# **MORGAN AND MORECAMBE OFFSHORE WIND FARMS: TRANSMISSION ASSETS**

**Notification of Intention to Submit a Change Request Application**

23 July 2025  
Rev: F01

**Notification of the Applicants' intention to submit a request for changes to the Transmission Assets  
Application**

**Drawing Number:**  
BP-GBR-MORG-REG-0176

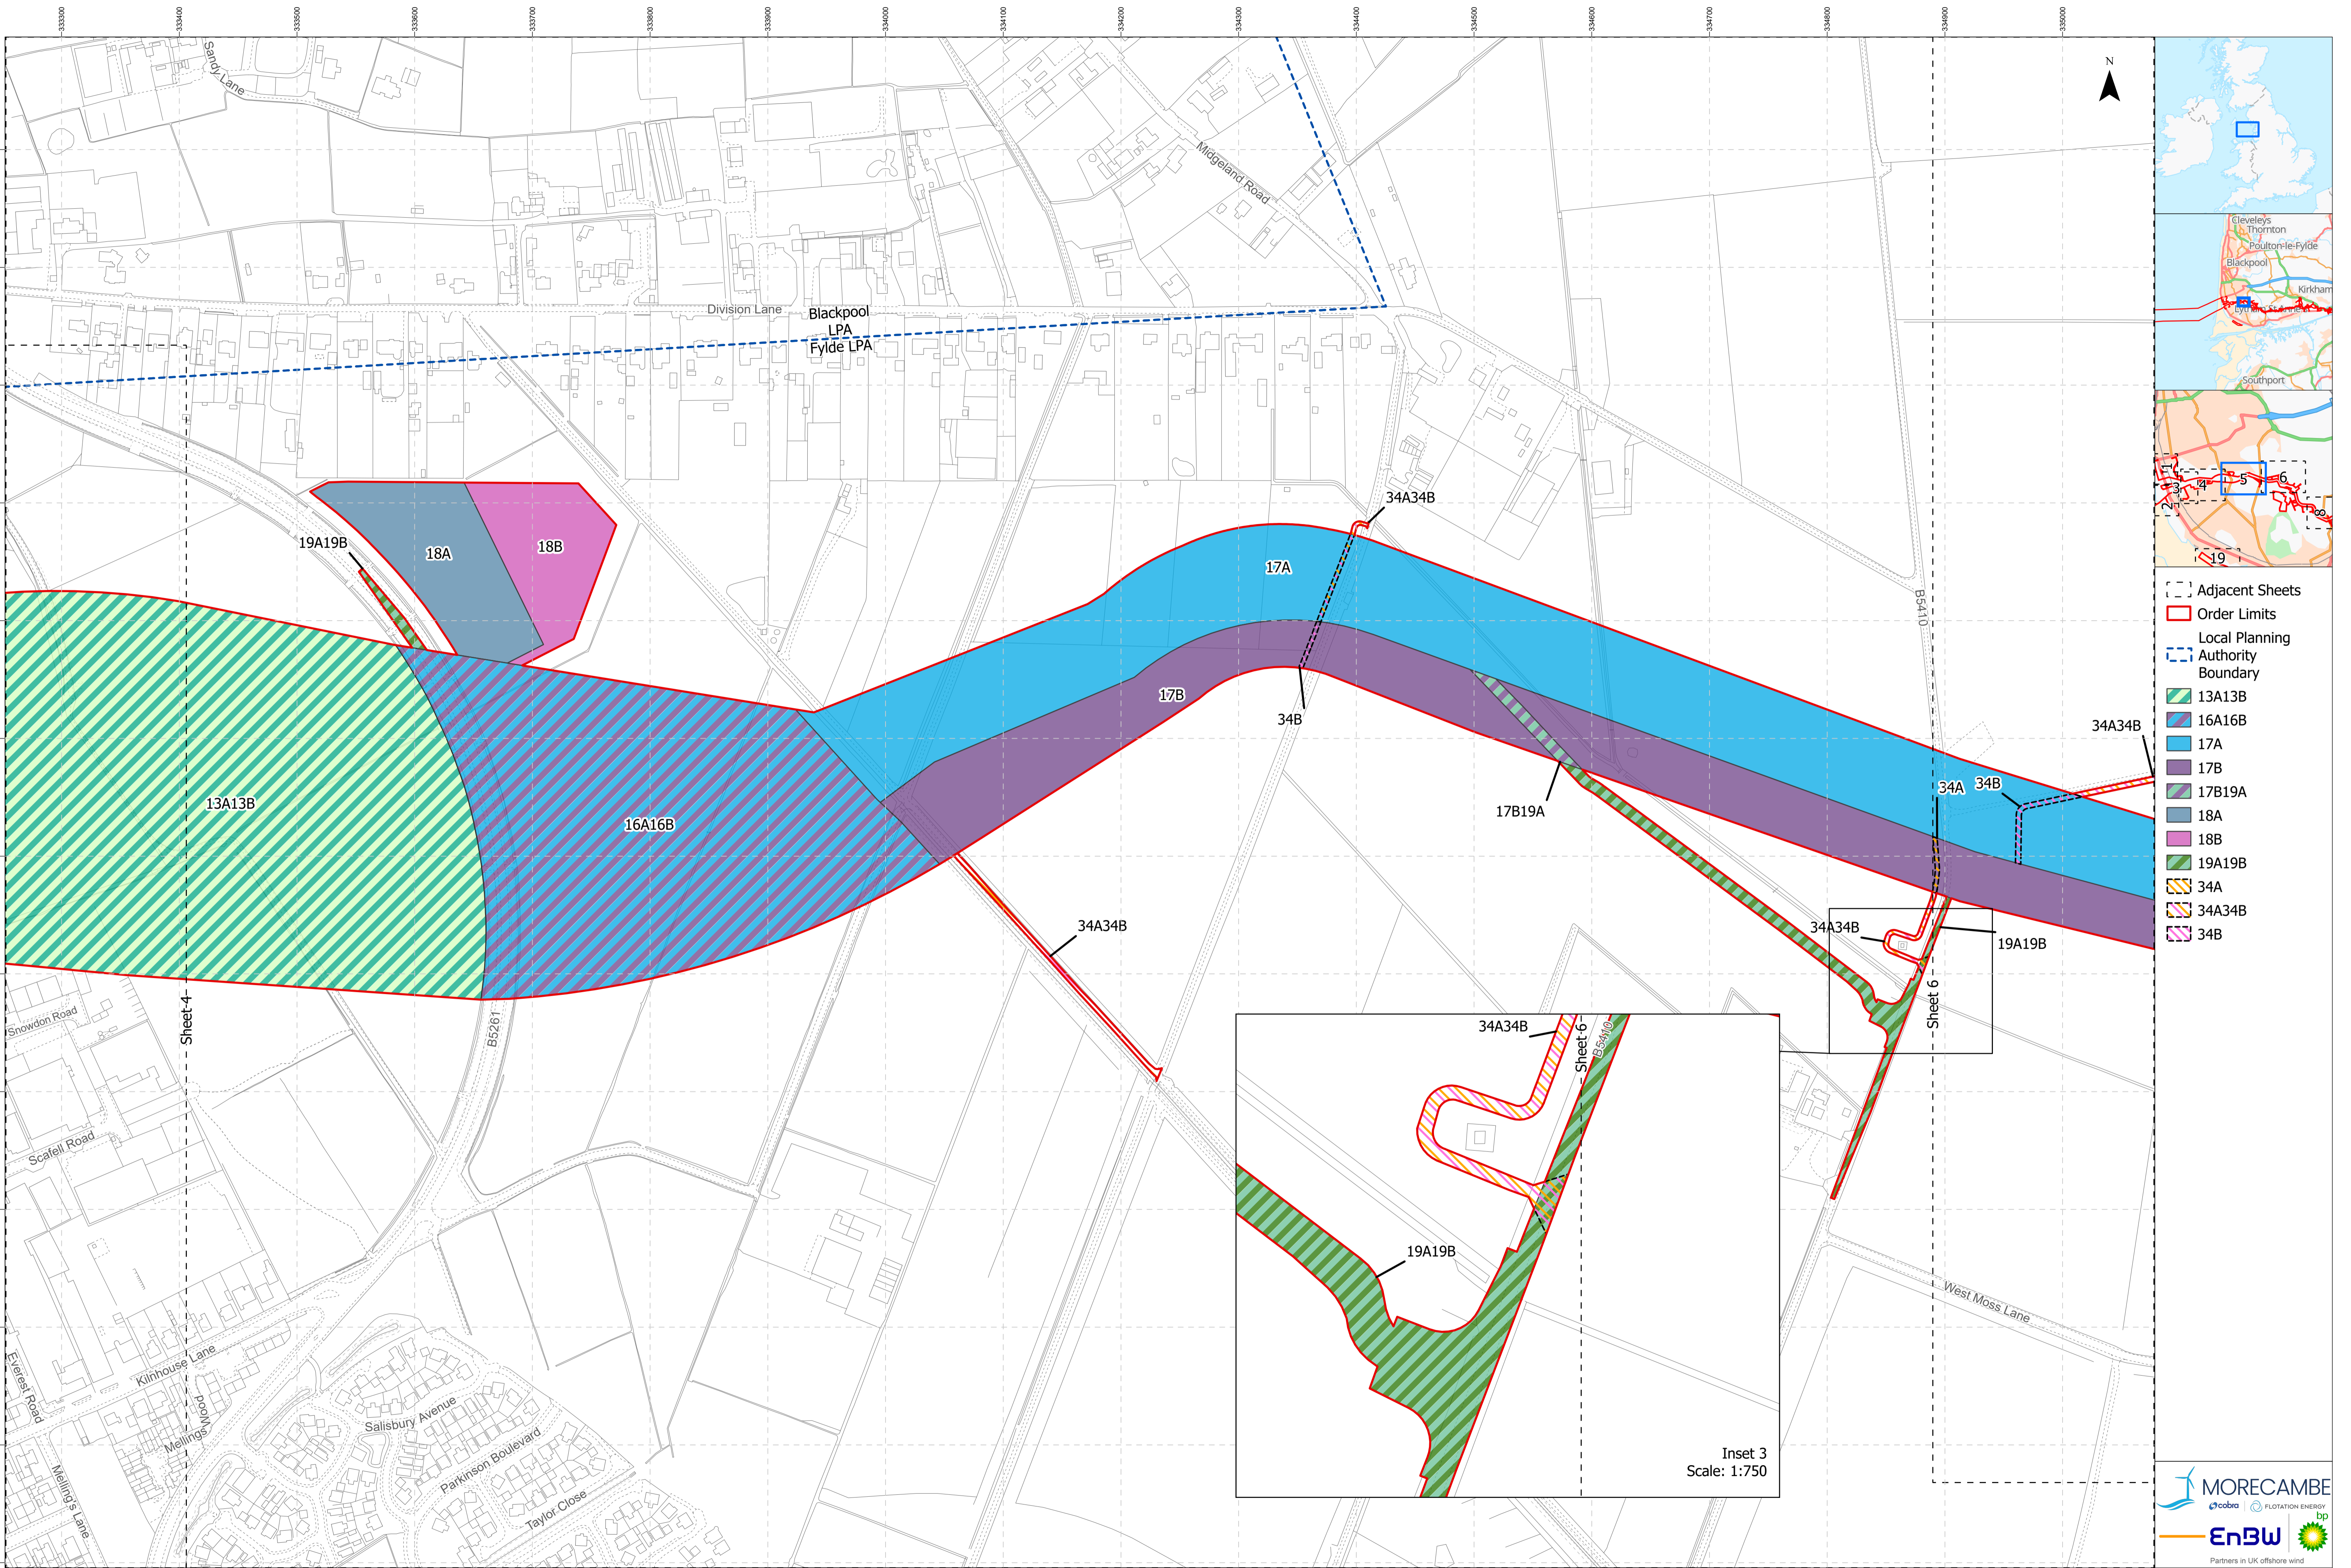
Change 4a involves amendment and reduction of the proposed Order Limits to remove any potential interaction with Runway 10/28 and land north of Runway 10/28 within Blackpool Airport operational land; currently included within Work Nos. 13A13B on Sheets 4 and 5 of the Works Plans – Onshore and Intertidal – Part 1 of 2 (REP3-007). The Applicants have made a commitment through negotiations with Blackpool Airport that cables will not be installed beneath Runway 10/28 and that the runway and land to the north of the runway is considered a restricted area, which means that no installation activities will take place. Therefore, this will result in a reduction of the Order Limits within Blackpool Airport. This involves the reduction in one plot of land (plot 04-024).
